## SOUTH TEES DEVELOPMENT CORPORATION

## **NET ZERO TEESSIDE DEVELOPMENT CONSENT ORDER**

# **RESPONSE TO COMMENTS ON RELEVANT REPRESENTATION**

529

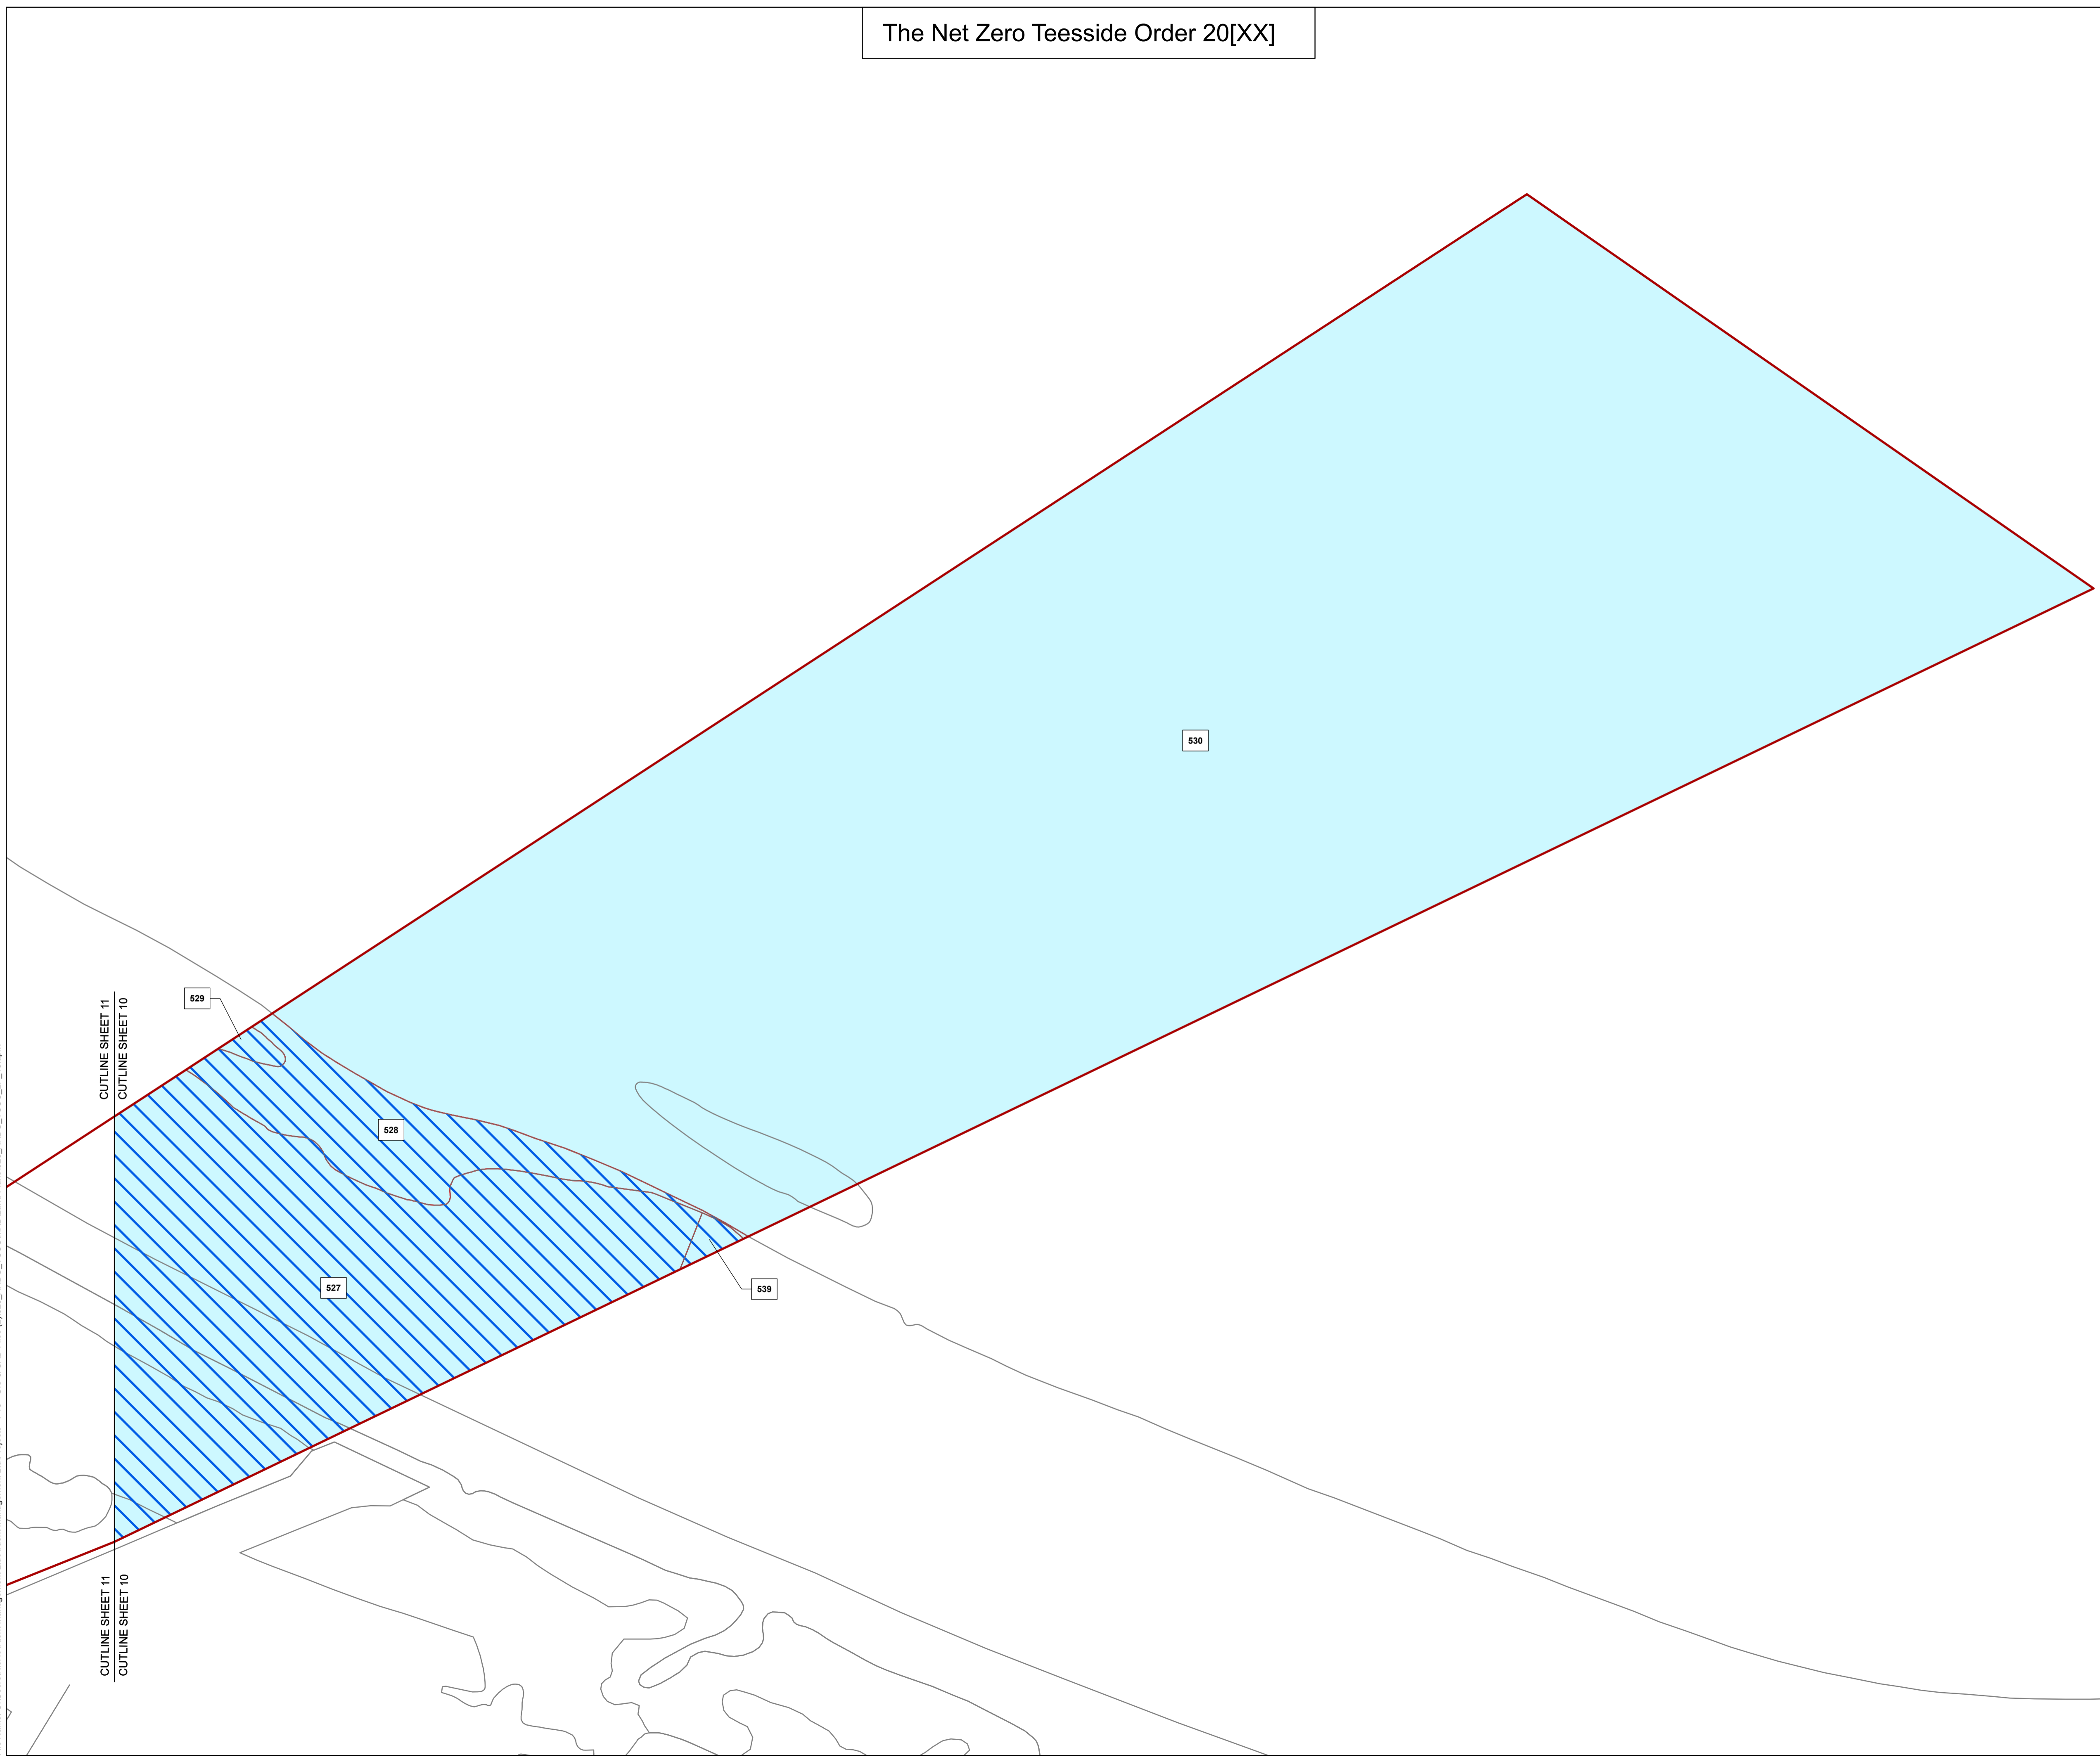
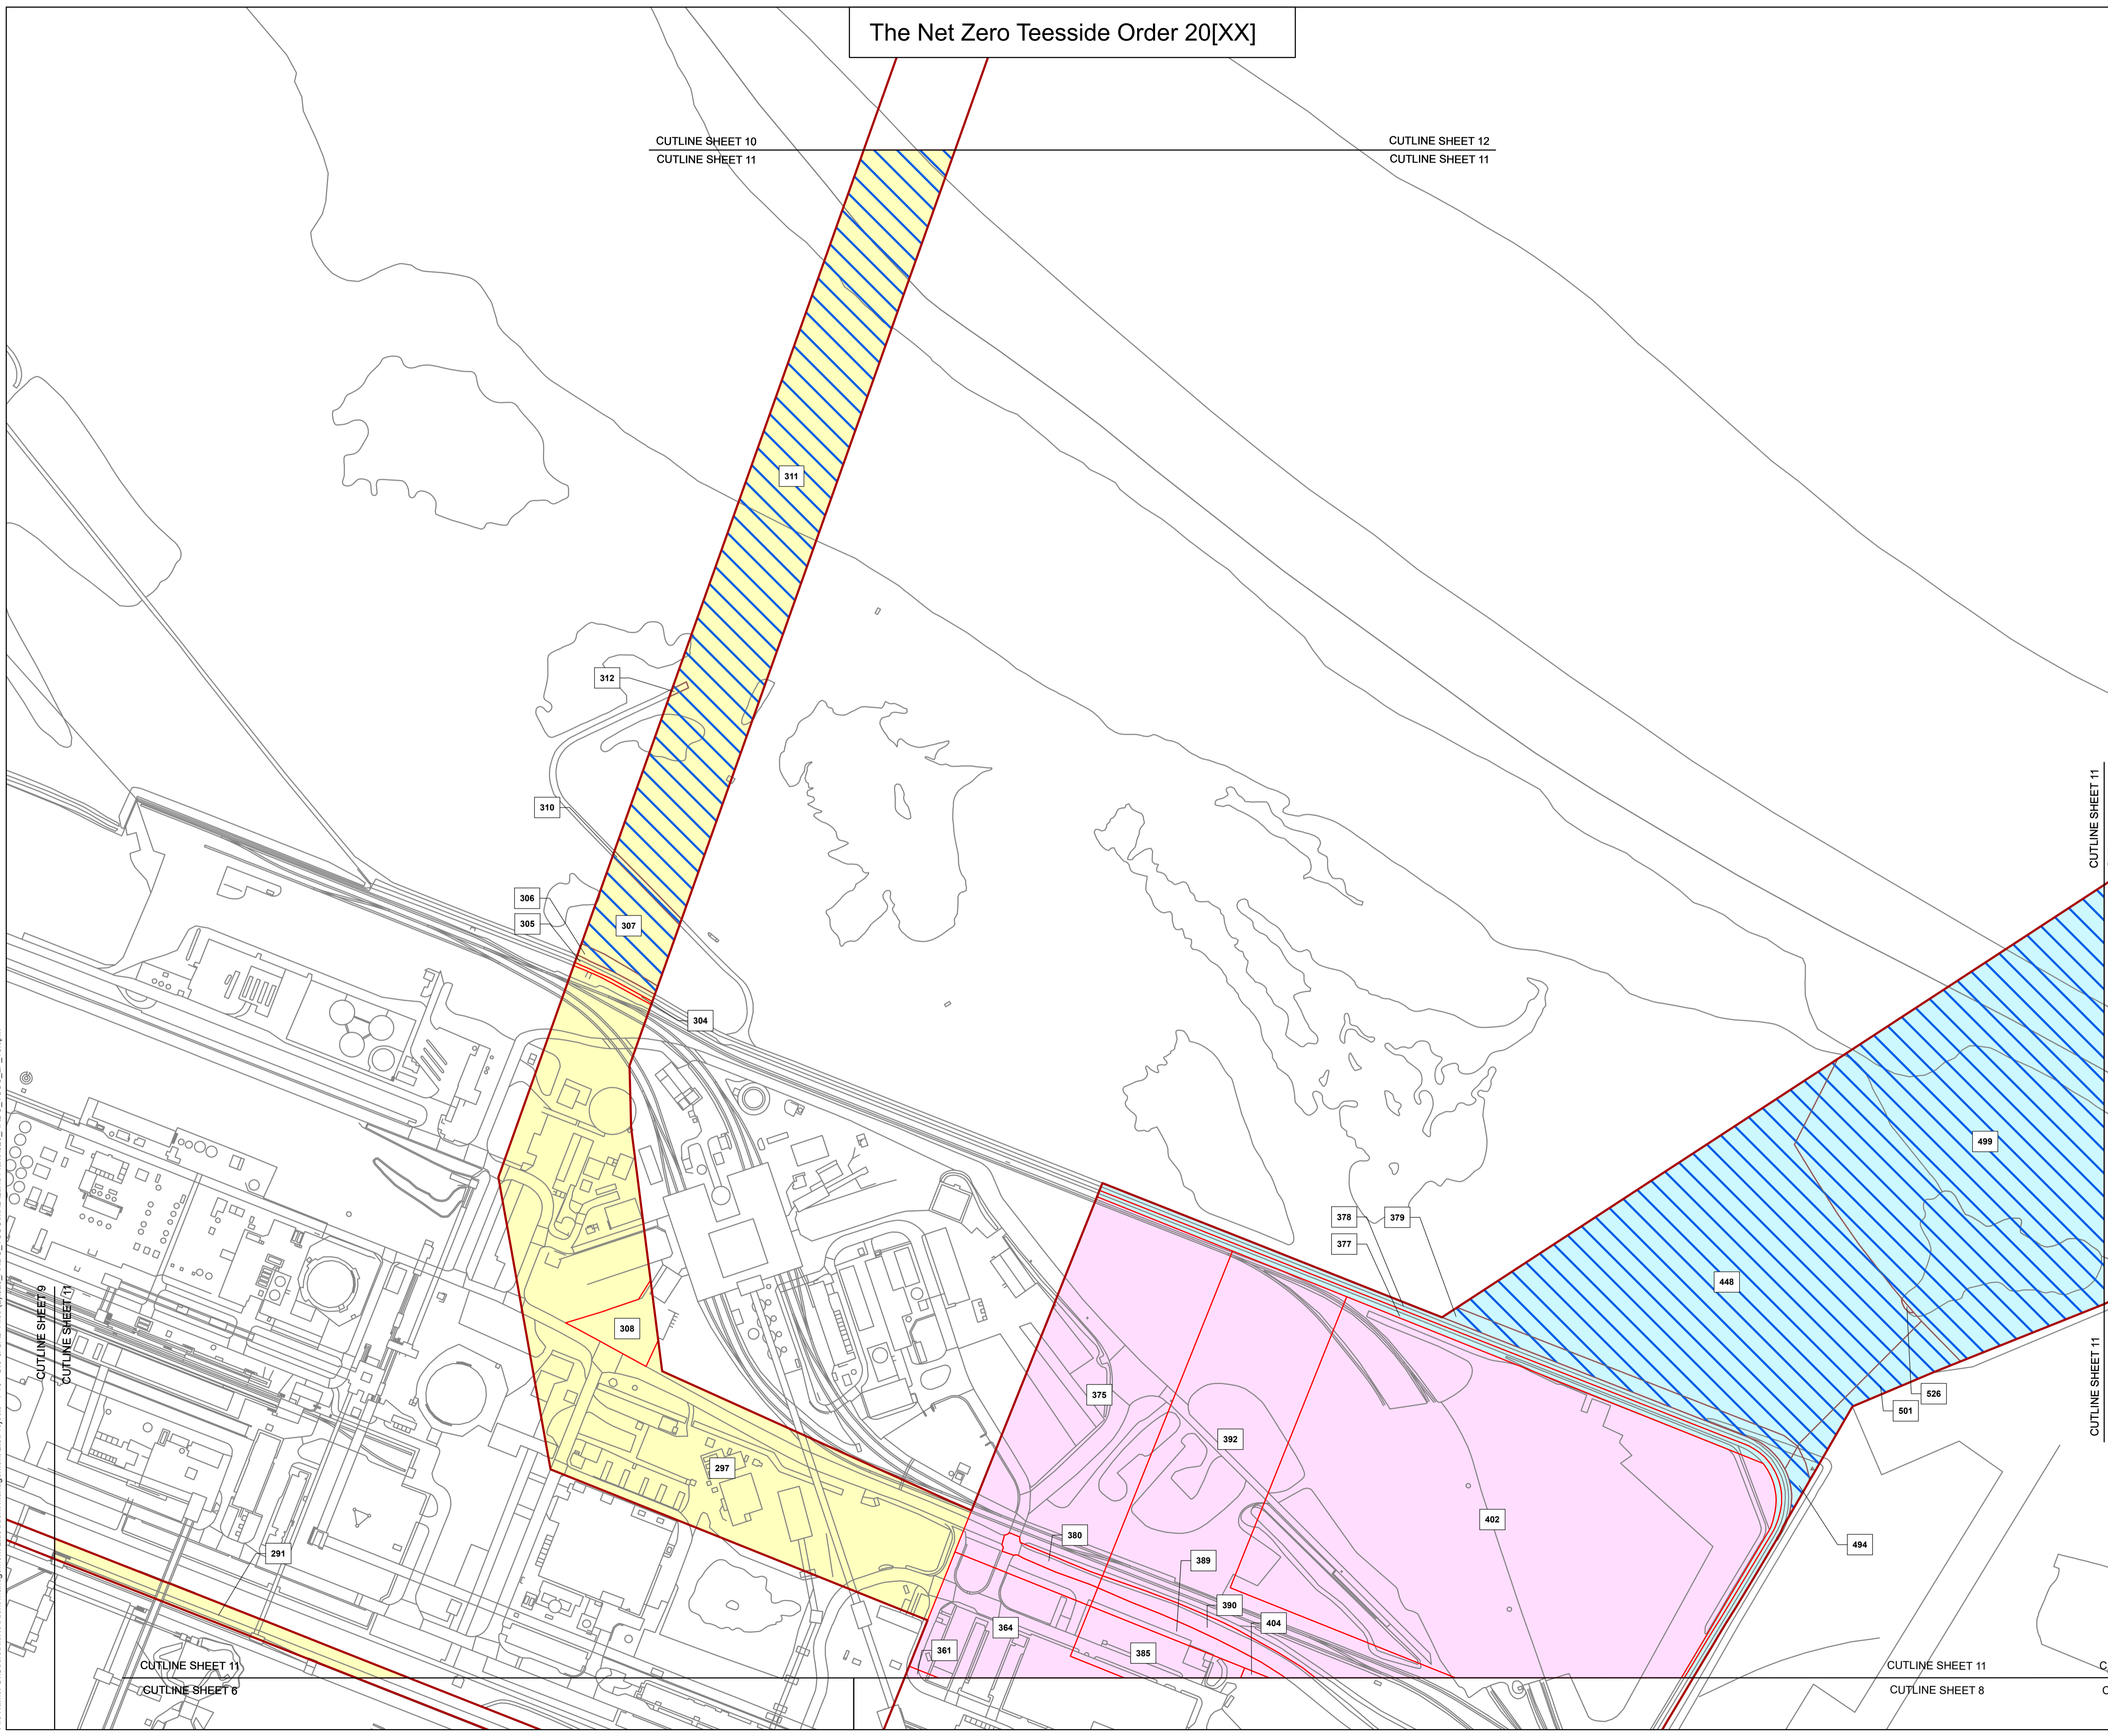
- 4.7 STDC retain significant concerns about the extent of its land included within the Project's Order limits for utilities. It is not clear from the application documents why plot 525 (and nearby plots) are so extensive given STDC's understanding of the Applicant's water pipeline requirements.
